# FINAL DRAINAGE REPORT

## DEYOUNG SUBDIVISION BENT GRASS MEADOWS DRIVE

December 18, 2019  
Revised April 20, 2020

JPS Project No. 031901  
PCD Project No. MS-20-001

EASEMENTS

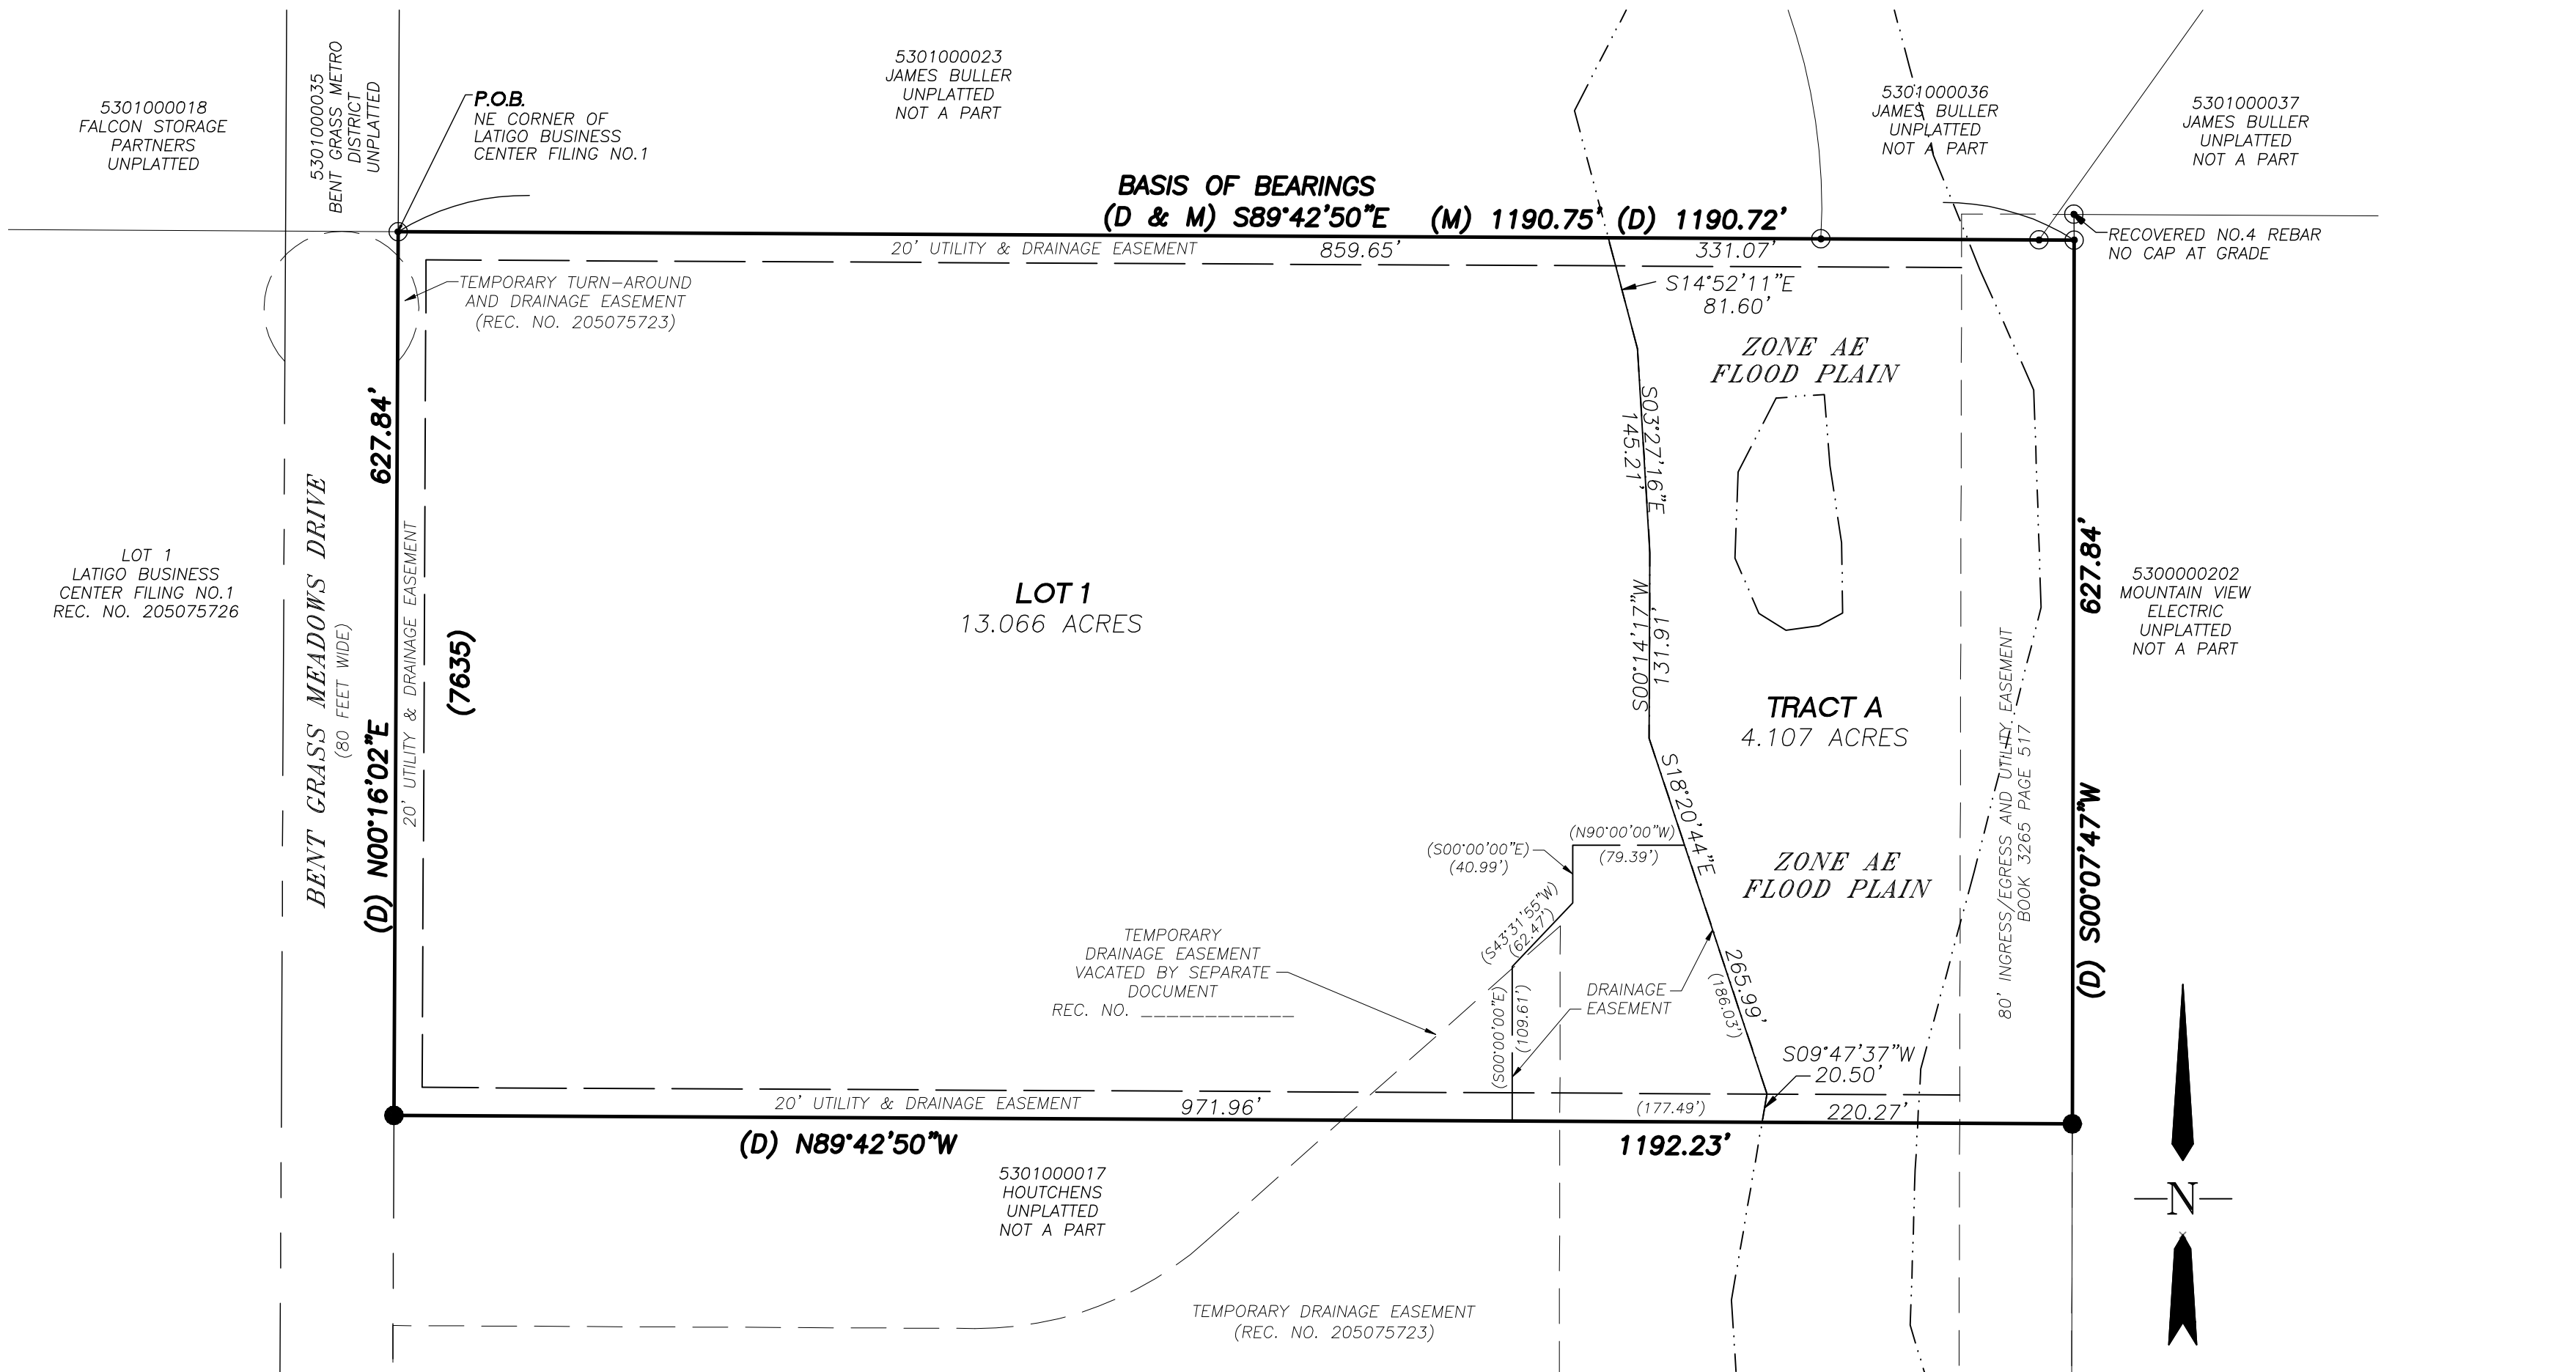
The following was in the first review comment letter: "prior to discharging runoff to the channel (waters of the State); downstream drainage easements (or other documentation of acceptance) are required for any increase in runoff to those properties. Revise the drainage plans and report as appropriate."  
Please indicate what is being done to address this.
